**Resubmission
STATEMENT
Dec..2020**

Amendment to Utility & Covered Porch Area.

SITE LEVELS
1:500

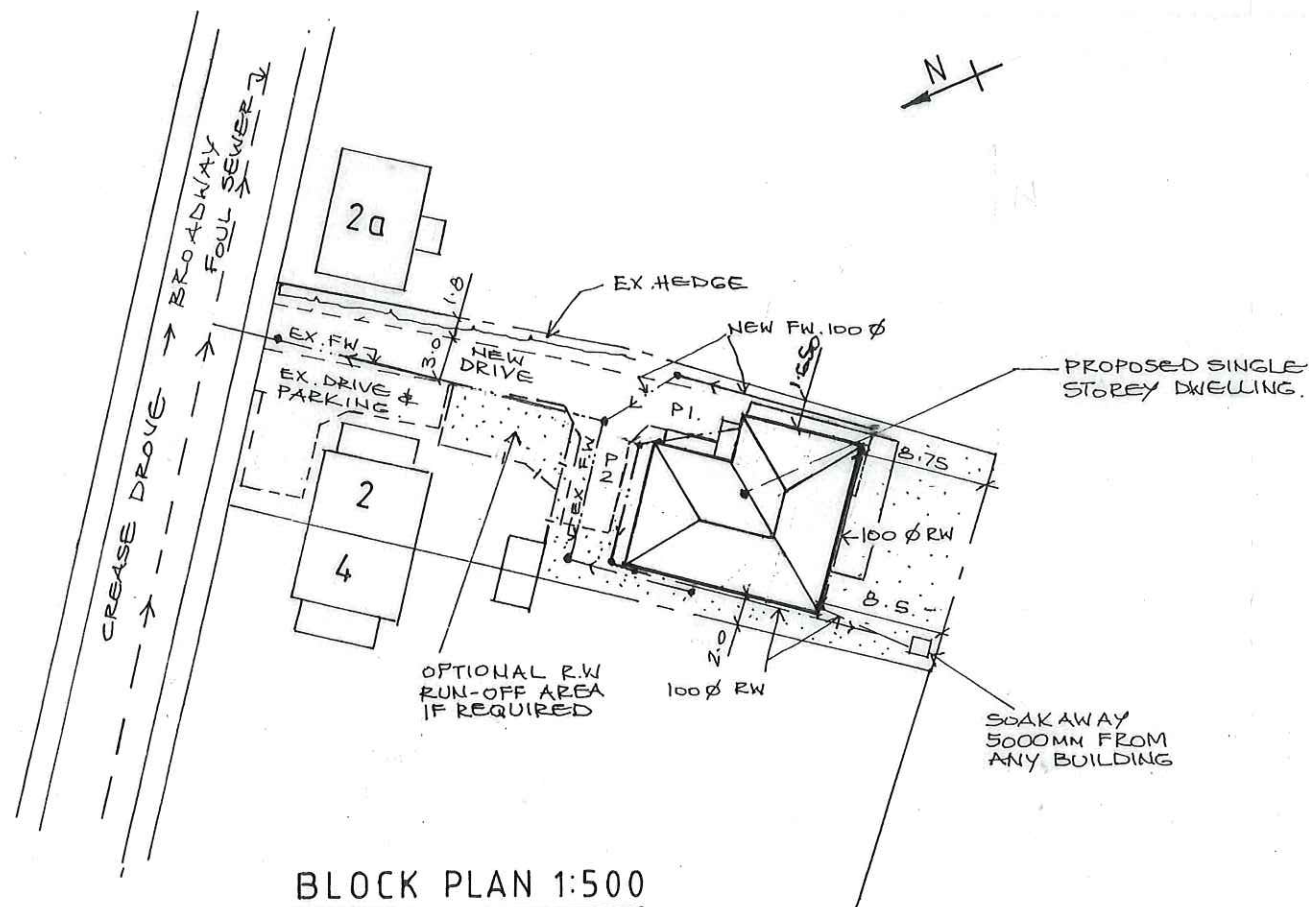
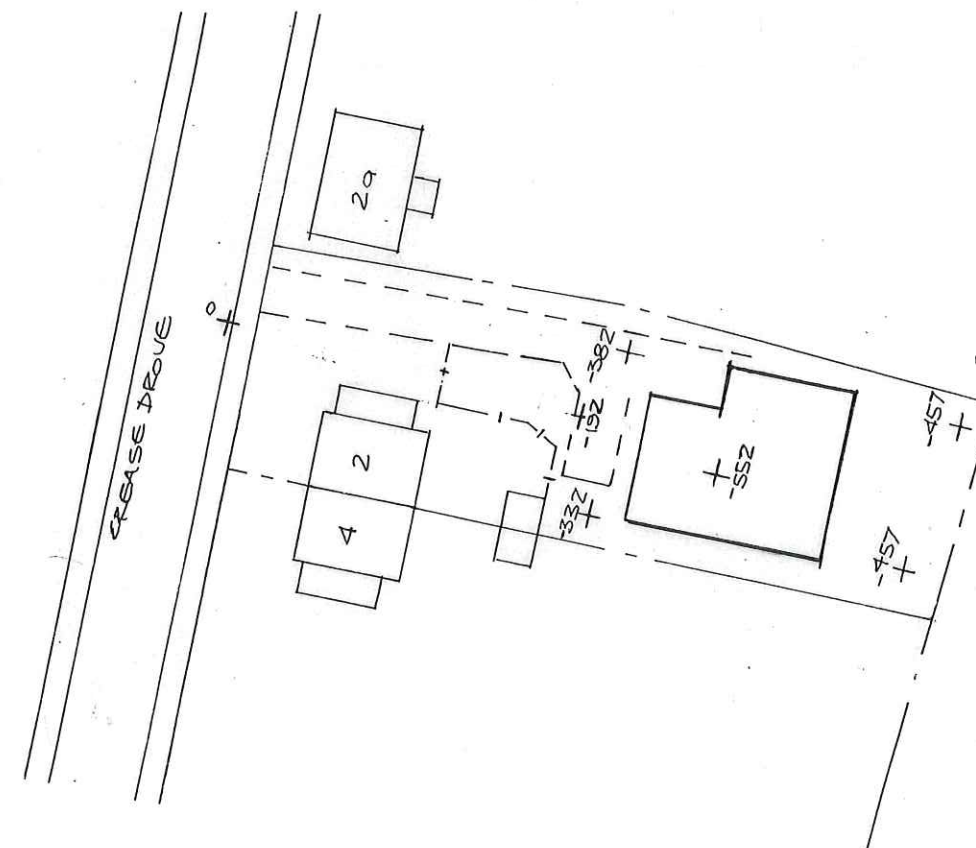
The Existing Boundary Hedge in its complete length is to remain. All other boundaries are to be 1.830 mtr. Feather Edge Fence with 300mm. Concrete gravel boards are to be set on a concrete base with total height/level as shown.

FFL /DPC as shown is set at 1.0 mtr above average ground level which is -321 below road level. (the later as agreed with Mr R. Fiddler & Mr D. Grant)

Ramp surfaces are to be of concrete, driveway & parking areas will be of gravel. Brick built (to match the dwelling) landings & steps down to the patio which along with Landing surfaces & pathways around the dwelling will be of a good quality paving slabs by Marshals or similar company. All associated levels as shown.

PROPOSED FLOOR LAYOUT 1:100

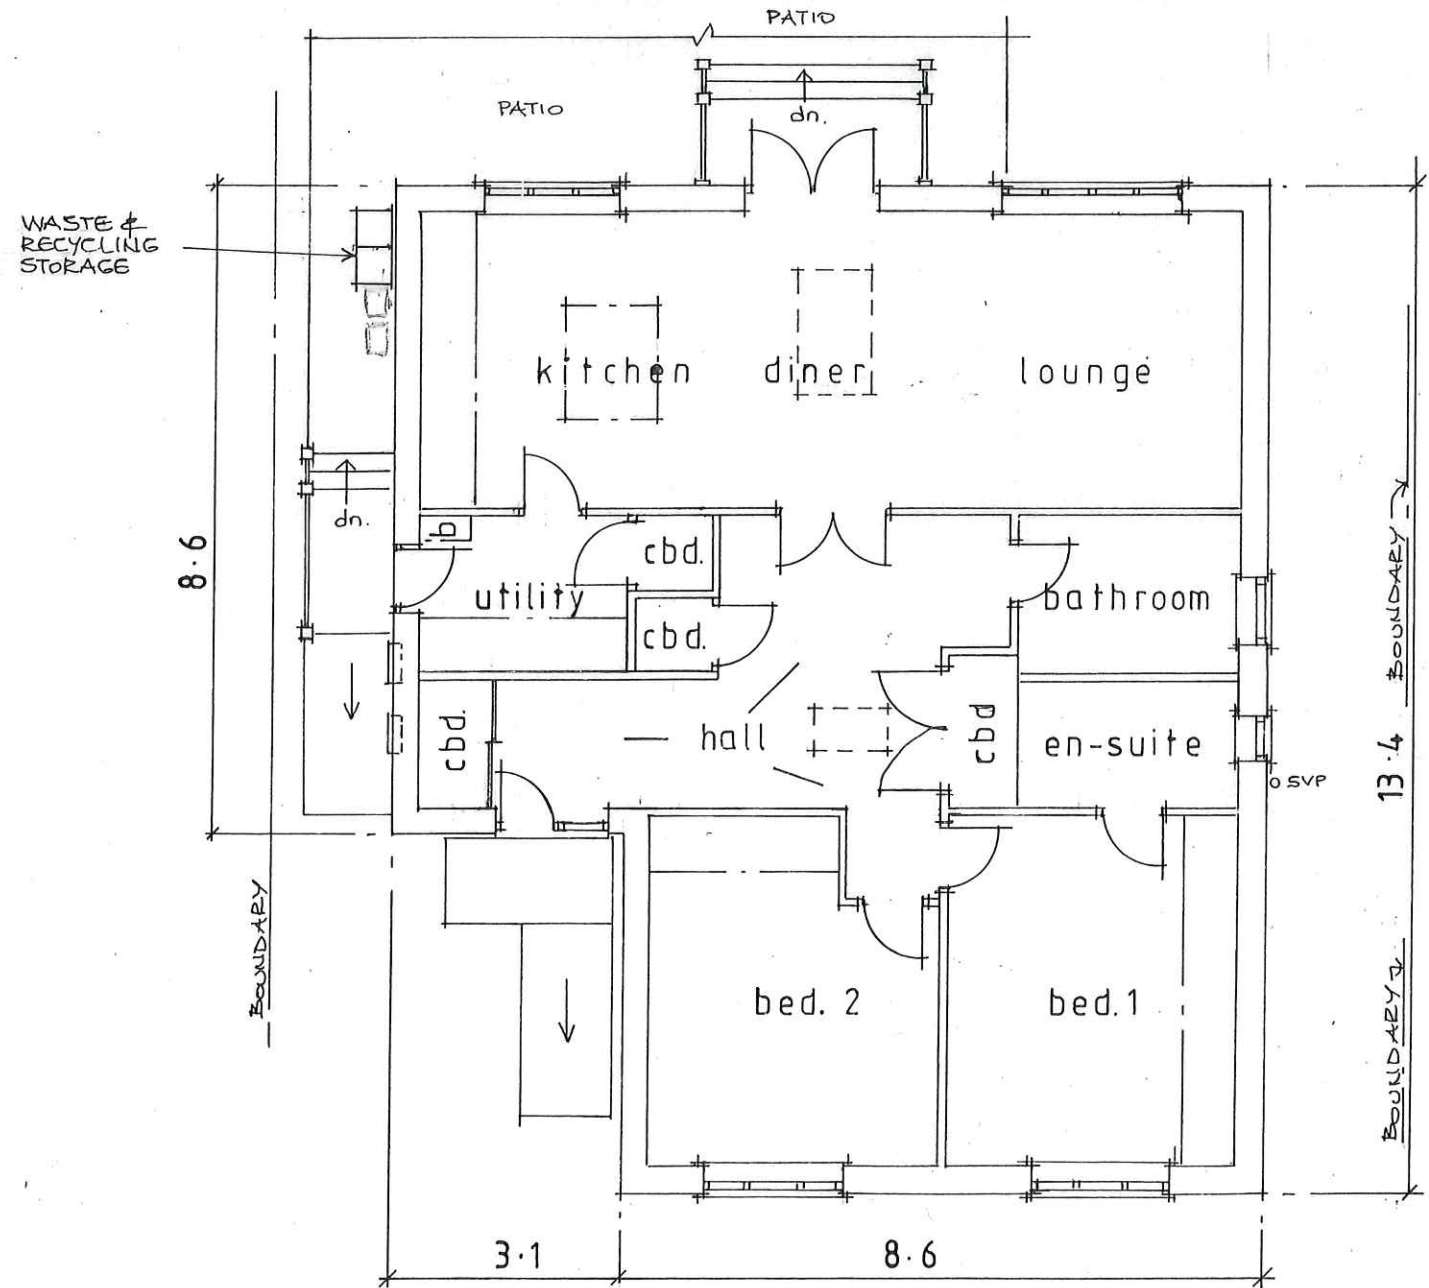
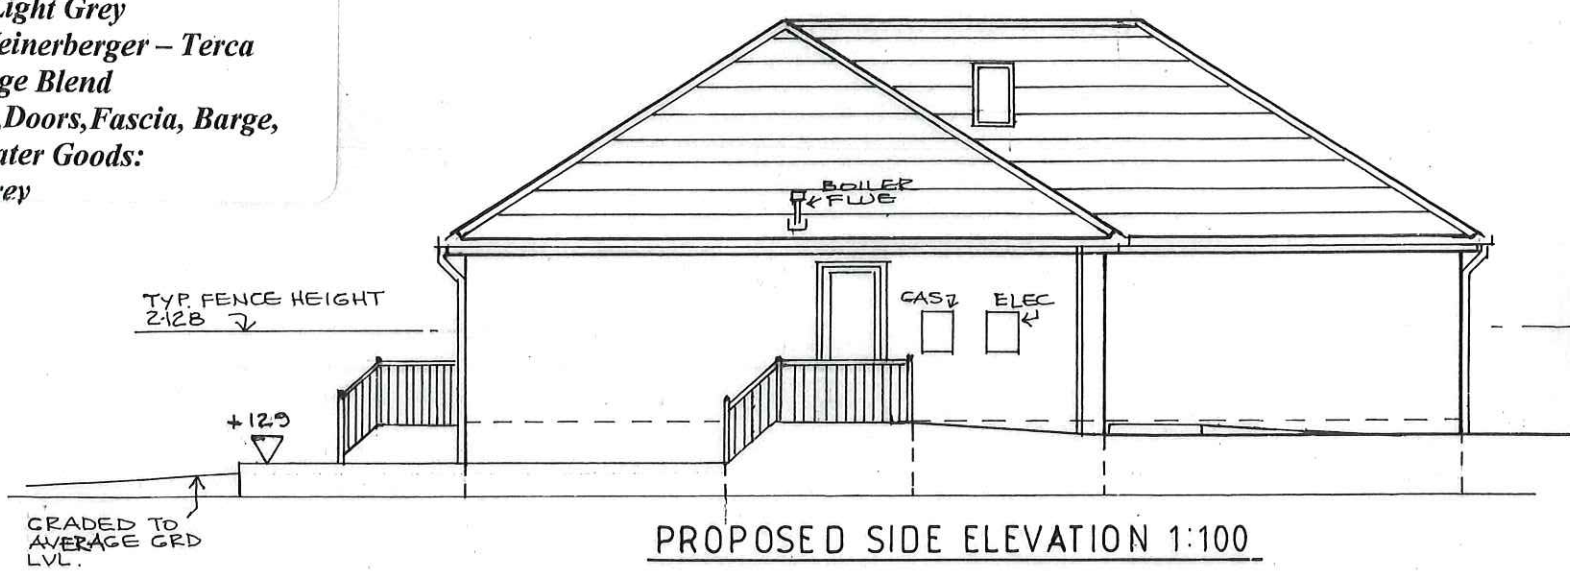
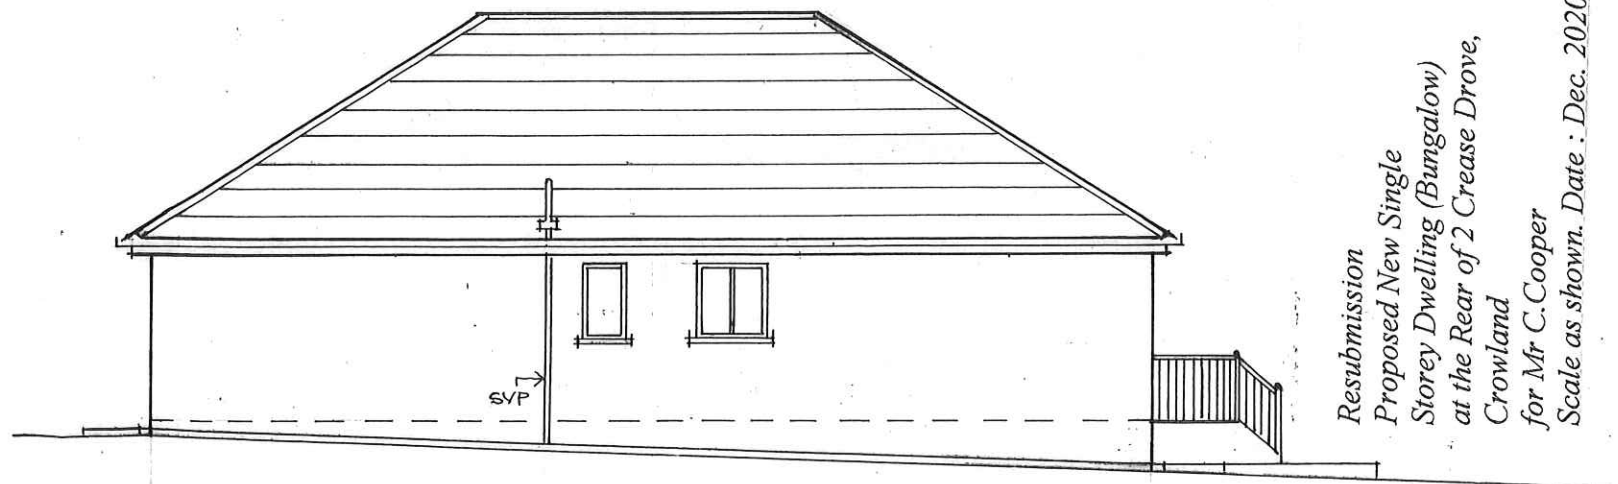
To incorporate the Utility & covered porch area into the kitchen/diner area to facilitate a more open plan internal design & to also facilitate the planning requirement to raise FFL to 1 mtr. above average ground level. By relocating the bathroom to the right hand side of the layout & removing the high level windows to the lounge, no overlooking of the dwelling to the rear of No.4 Crease Drove is achieved. A change to the approved French doors & panels to the lounge, will now be a window, this will ensure that access to the patio from the diner kitchen will be 7mtrs from the boundary of the dwelling to the rear of No 4 Crease Drove.

The change from a gabled roof is firstly to mitigate the effects caused by the raised FFL. & secondly to mitigate any loss of light to the dwelling directly adjacent.
